Our ref: NO/2024/116007/01-L01
Your ref: 3/2024/0177
Date: 16 April 2024

**PROPOSED CONSTRUCTION OF AN EARTH BANKED SLURRY LAGOON AND
ASSOCIATED LANDSCAPING
HIGHER GREENHEAD FARM, GISBURN ROAD, SAWLEY, BB7 4LQ.**

Sections
Scale 1:200 @ A3

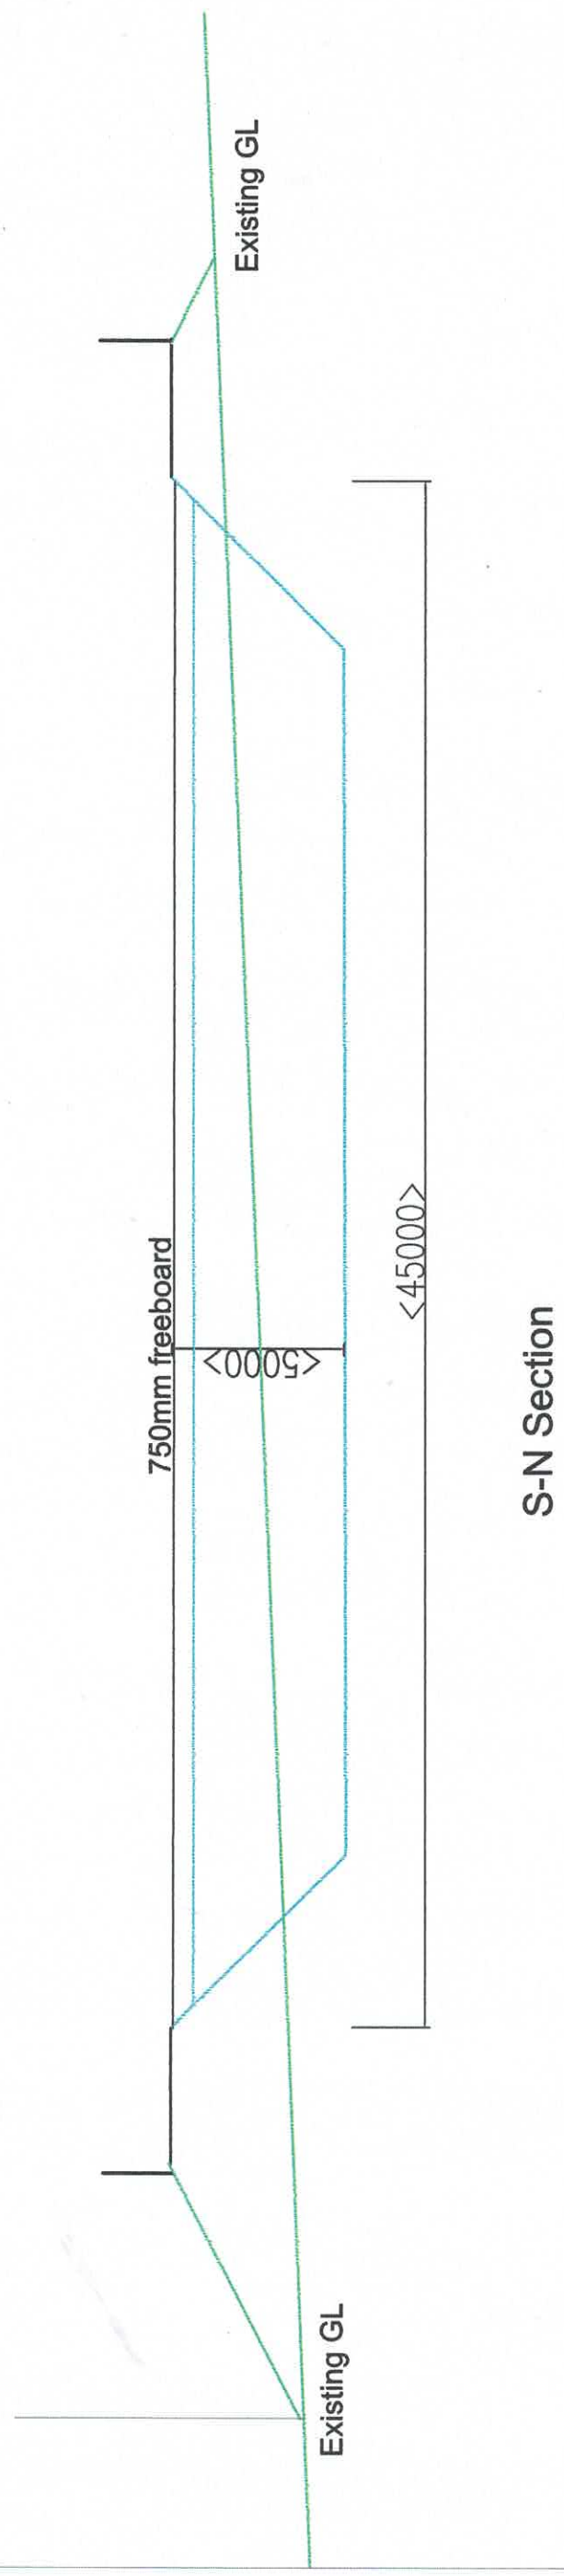
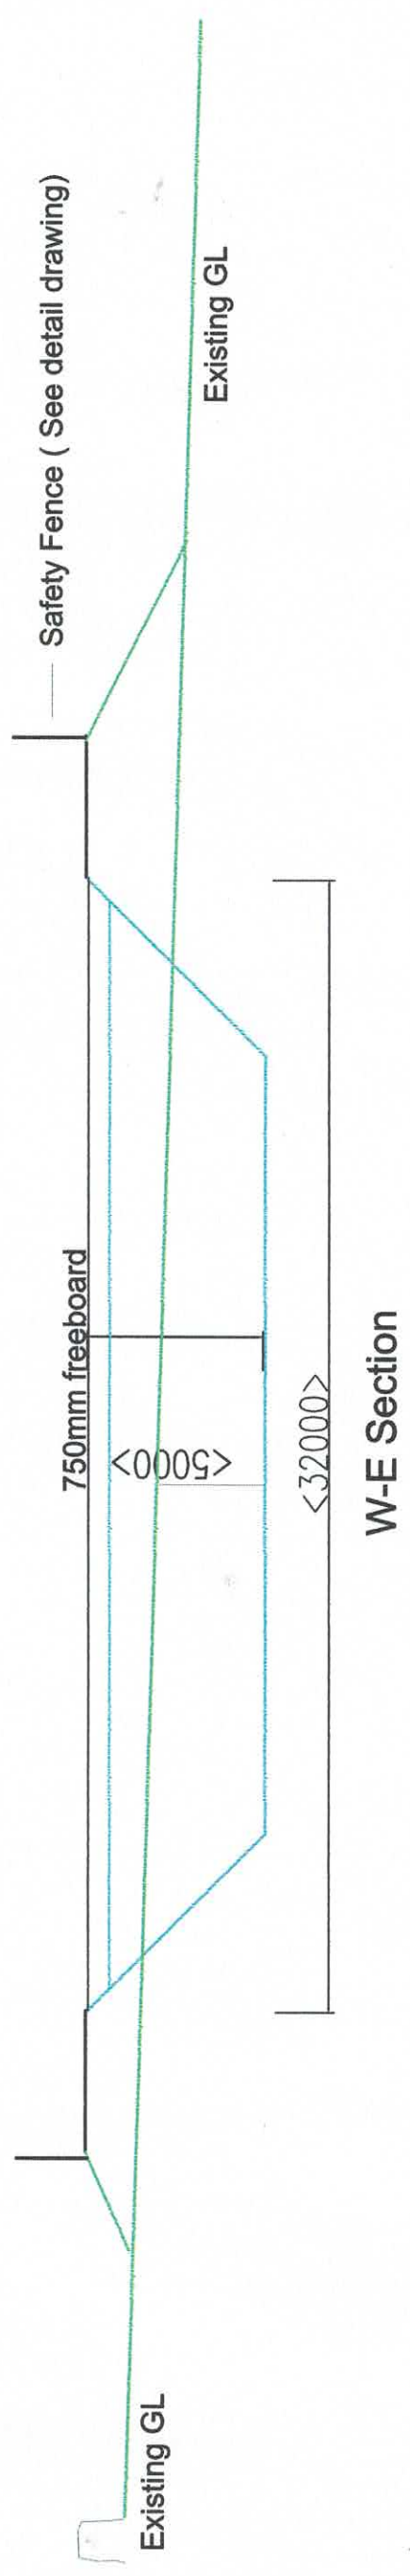
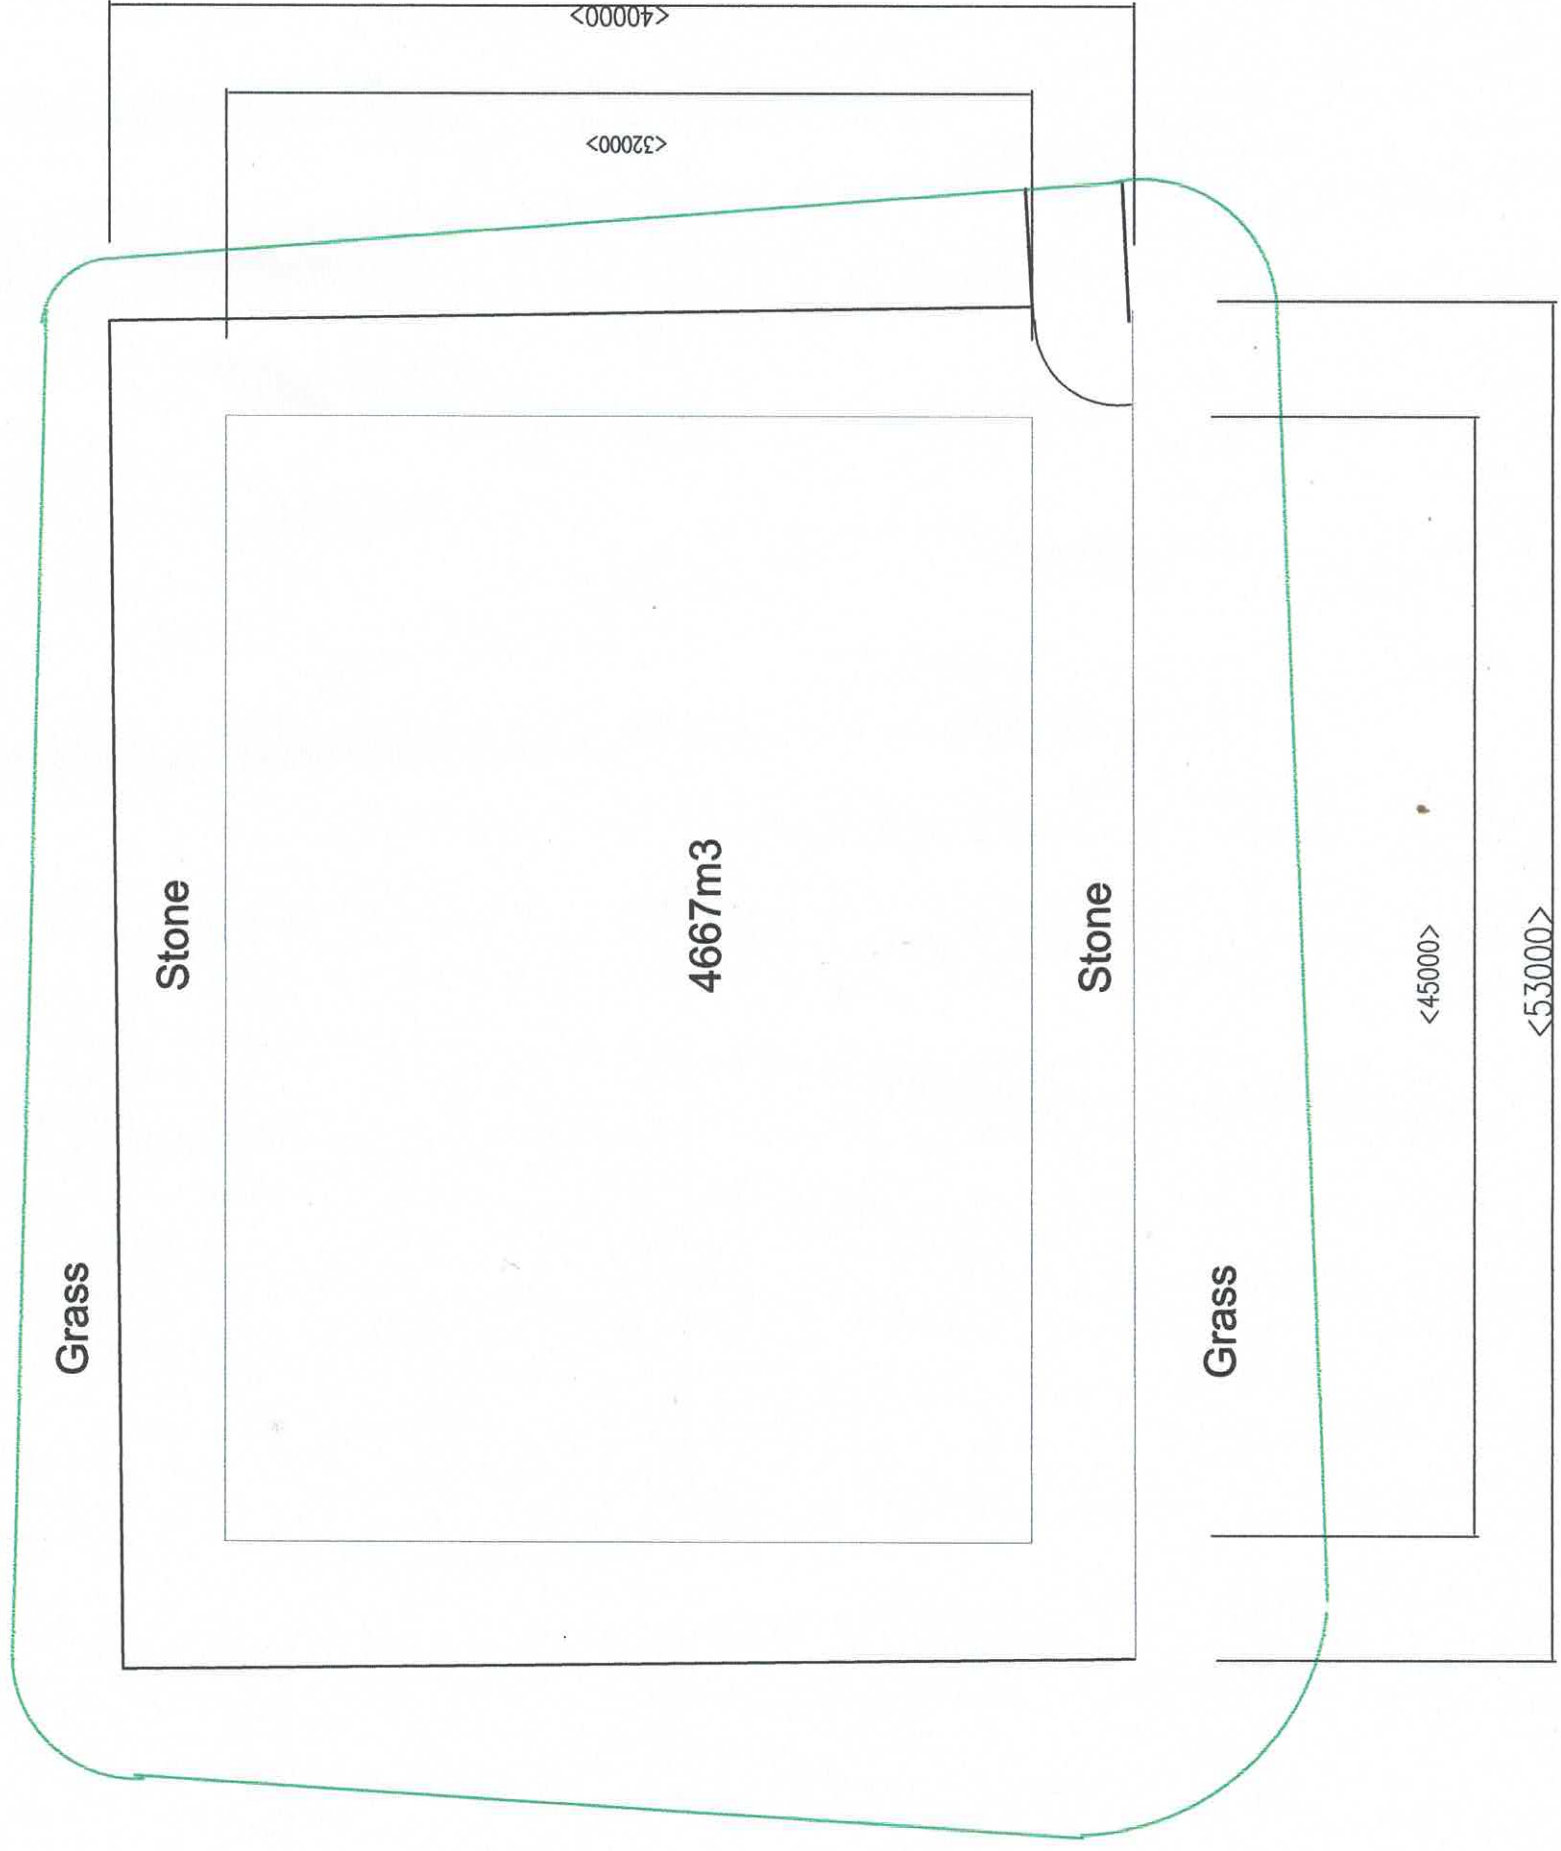
Any proposals for earth-banked slurry lagoons will require an impermeable clay base to a minimum depth of one metre. To ensure compliance with SSAFO, applicants will need to provide us with details of percolation tests to demonstrate that the ground conditions at the base of the lagoon are appropriate. Where permeability tests show that the soil or underlying ground is not suitable, it will be necessary to use a synthetic material or import impermeable soils to act as a liner for the lagoon. The earth banked walls will also need sampling as sufficient clay soils (not less than 20% and no more than 30% clay content) are required to make the banks stable. The lagoon should be sited sufficiently far away from any watercourses and land drains.
